**FINAL DRAINAGE LETTER  
FOR  
LOT 1, WOODMEN HILLS FIL NO. 7H**

December 2020

The purpose of this drainage letter is to confirm that the proposed development of the Falcon Eye Care Commercial building proposed on Lot 1, Woodmen Hills Filing No. 7H conforms to the concepts presented in the “Final Drainage Report for Falcon Eye Care, Woodmen Hills Filing 7. Lot 4” prepared by Kiowa Engineering Corporation. The site layout developed with the replat is being used in final site design and concepts presented in the final drainage report are being followed in final site design submittal.

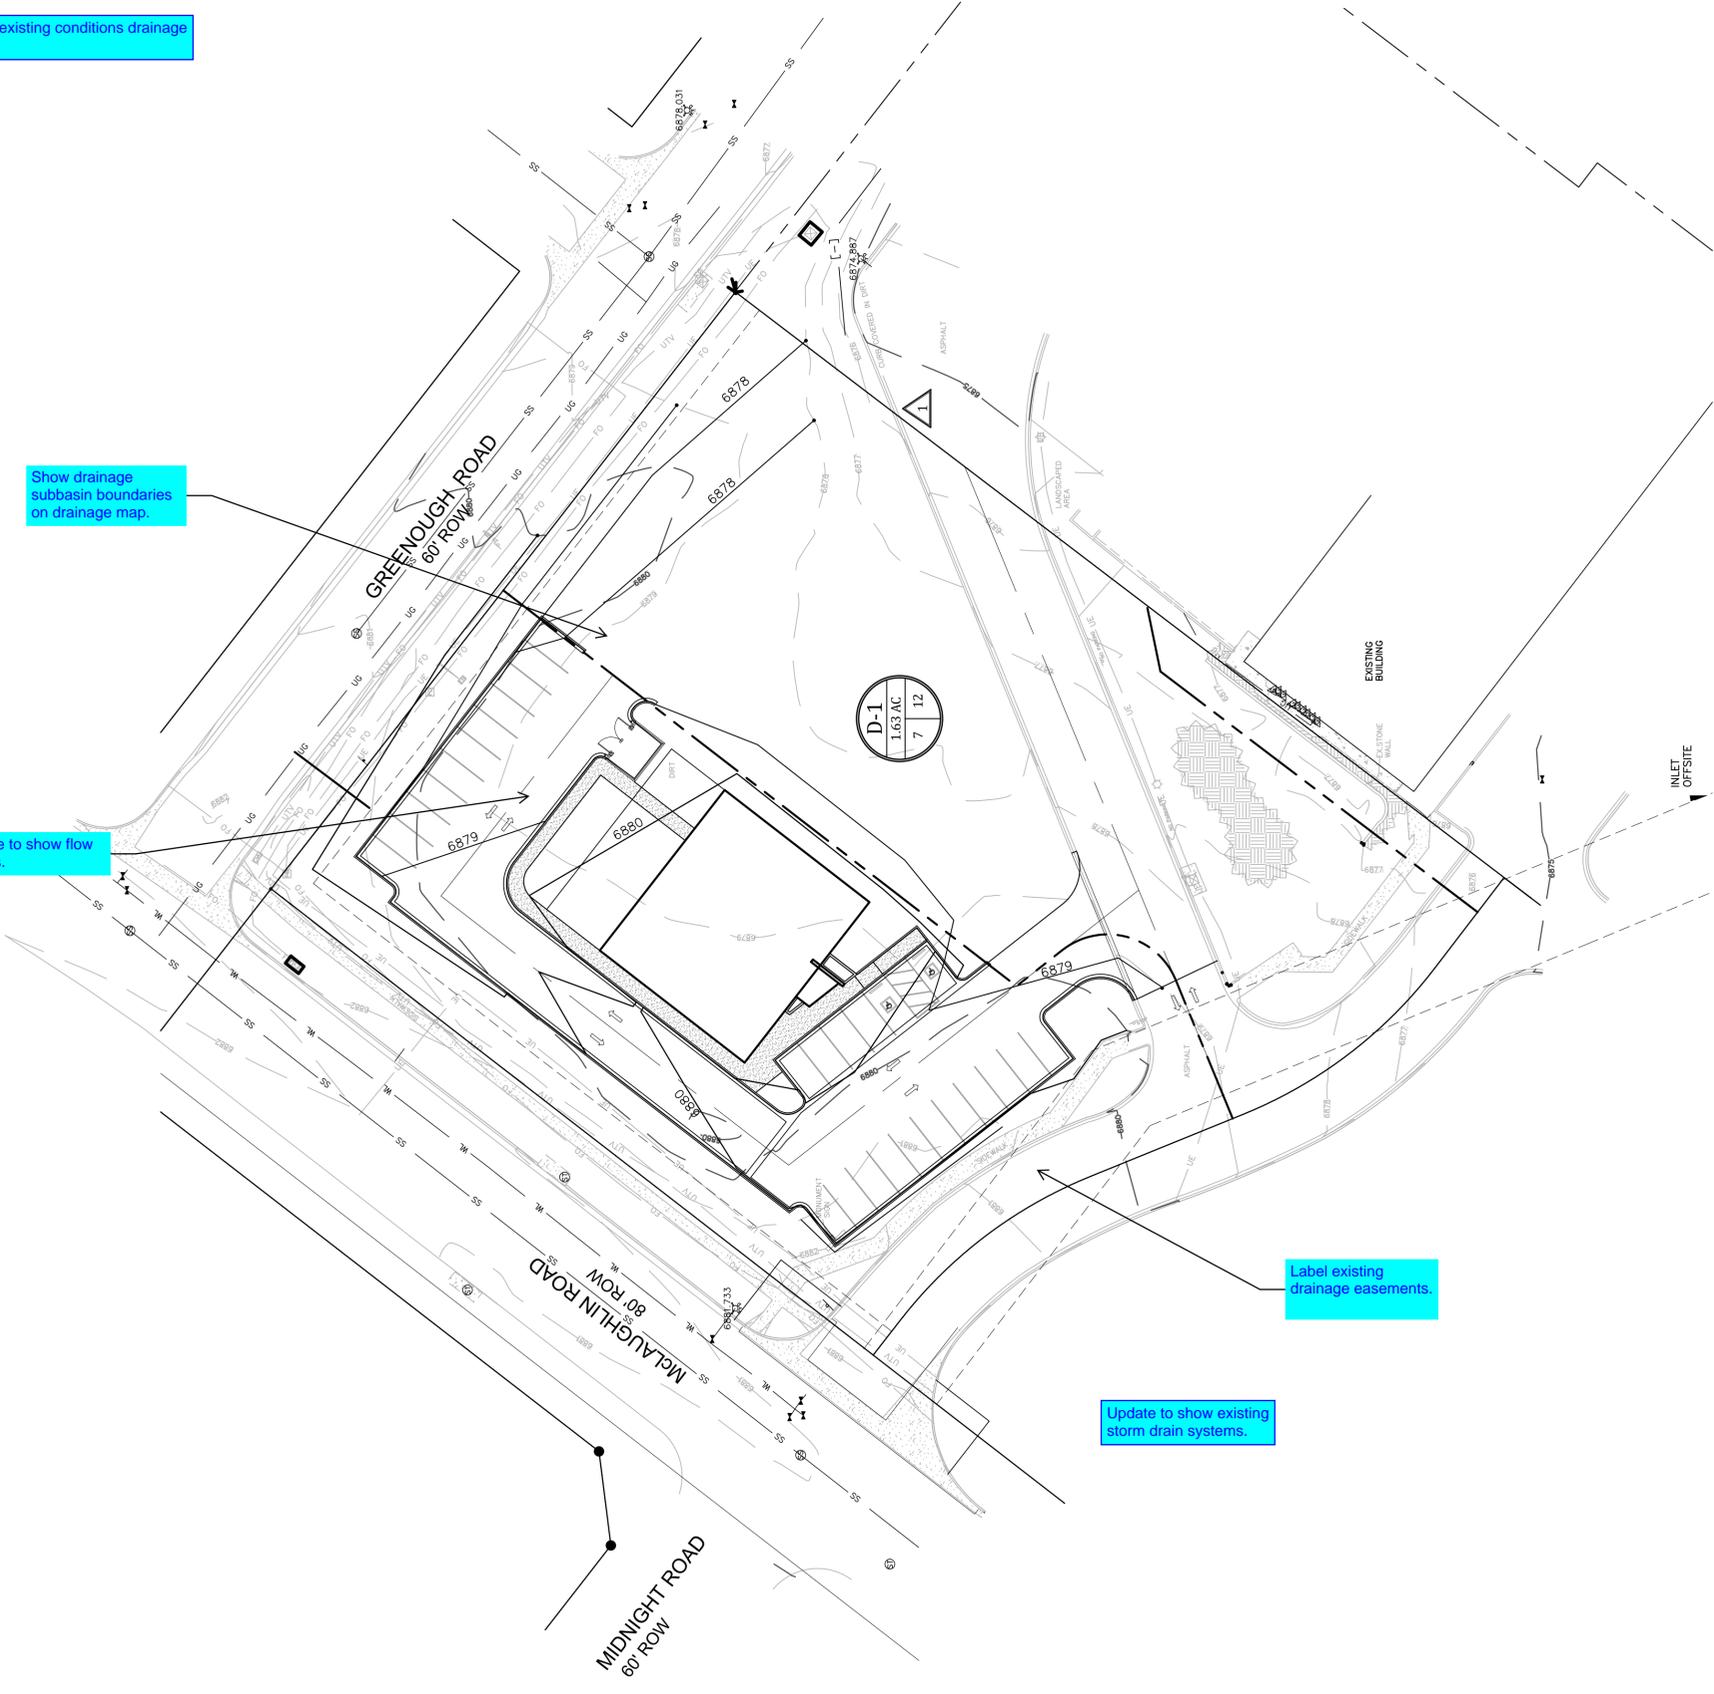
Show and label these parking lot inlet(s) that are applicable to this site on drainage map on the last page. Also describe them in more detail, in this text and show capacity calcs.

Flow for the northern half of the site is directed to and concentrated at a curb cut and riprap pad. Describe this in more detail. Is there an agreement with the adjacent property owner that allows this flow to be conveyed across their lot? Please elaborate.

Show drainage flow arrows.

Show and label ultimate inlet that site runoff is conveyed to.
